From: Andrew Riley <andrew.riley@ashwoodhomes.co>
Sent: 01 September 2020 14:41
To: Armour, Susan (SHBK)
Cc: Adam Jagger; Buttery, Lucy
Subject: RE: H09-0523-20
Attachments: We sent you safe versions of your files; 2020.09.01 - COVERING LETTER.pdf; 35-GMD-01 - REV.A - Gas Membrane Detail.pdf

I've had a quick look over the GeoDyne RMS, your amendment letter of 19/8/2020 and your drawing ref 35-GMD-01 'Gas membrane details' dated Aug 2020. My comments are quick and to the point as today is my only working day this week and Lucy is keen to resolve this week.

DRAWING: Gas Membrane Details

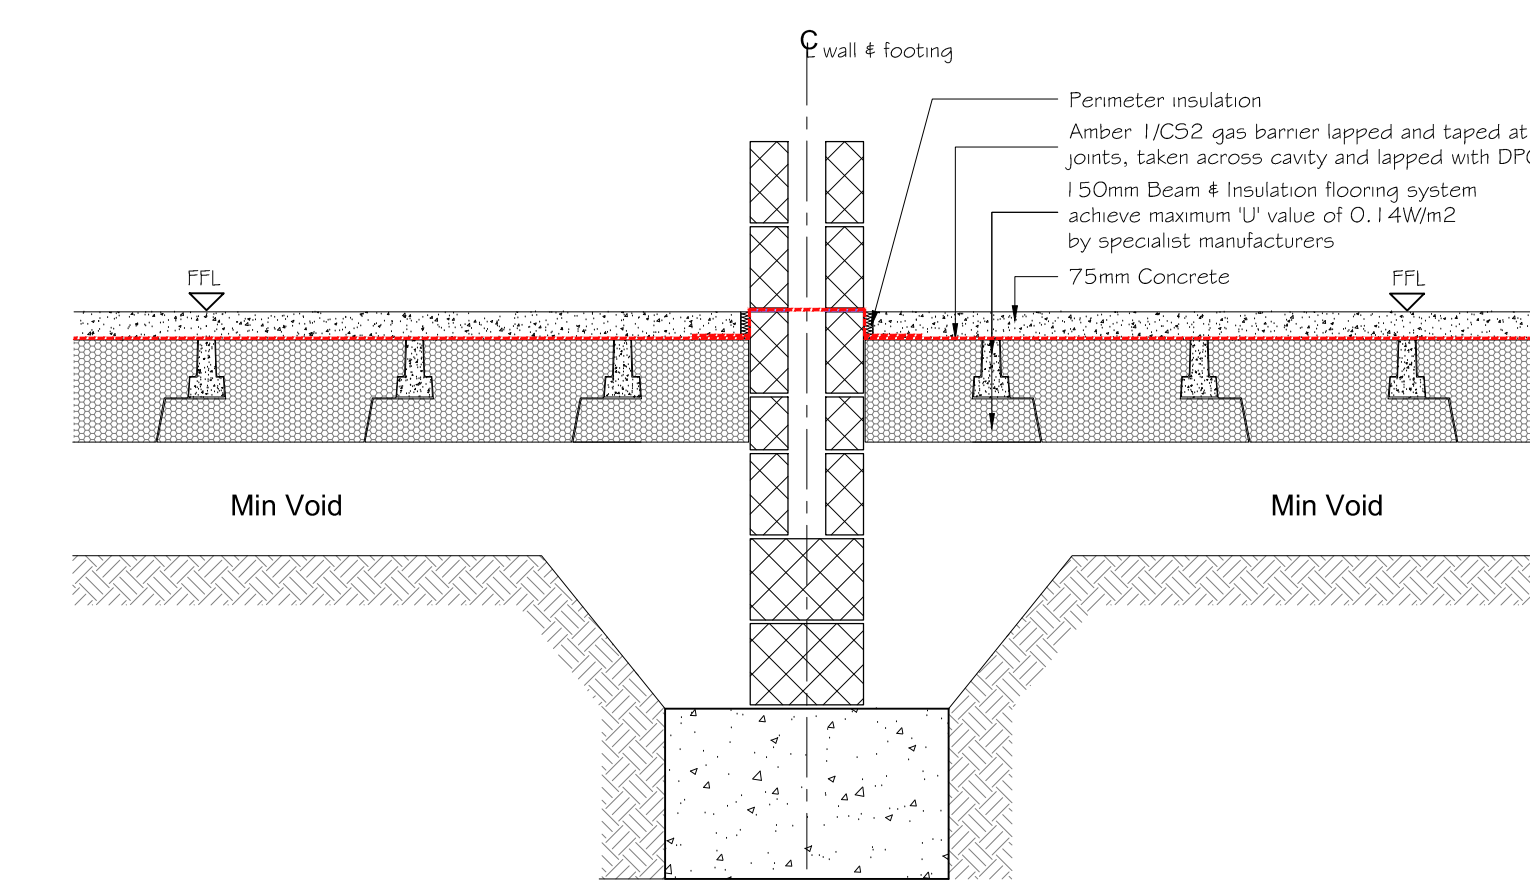
Regarding the gas protection measures, there are some significant discrepancies between the GeoDyne report and your drawing, as well as some missing detail as follows:

- GeoDyne has specified CS2 in accordance with BS8485:2015+A1:2019. This is different to the NHBC traffic light system, and not the same as Amber 1. They are not interchangeable. **Please find attached revised drawing with reference to NHBC traffic light system removed.**

- The exact membrane to be installed has not been detailed. **Visqueen low permeability gas membrane, or similar approved to be installed.**
- The GeoDyne report recommends a specialist contractor installs the membrane. **A suitably qualified and experienced contractor will be appointed**

- The validation requirements set out by GeoDyne are different to those on your drawing. **Please find attached revised drawing with updated validation requirements**

- There is no spacing detailed on the periscopic vents, please confirm the subfloor cross ventilation details. **215x65 air bricks with periscope on at least two sides of the building are to be installed. They are to be spaced at a maximum 2M centres, providing a minimum 1500mm²/m run of wall**

- Please confirm these are NOT timber framed houses. **Houses are to be traditional masonry construction**

Please provide the proposed membrane details asap, as well as confirming you will be using a specialist installer. Will GeoDyne be providing the third party verification? Please can these details be added to the drawing.

As per the Geodyne report, all works are to be carried out by a suitably qualified contractor, and the installation to be verified by means of a quality control check sheet. Third party verification of the membrane will be carried out by the LABC building inspector.
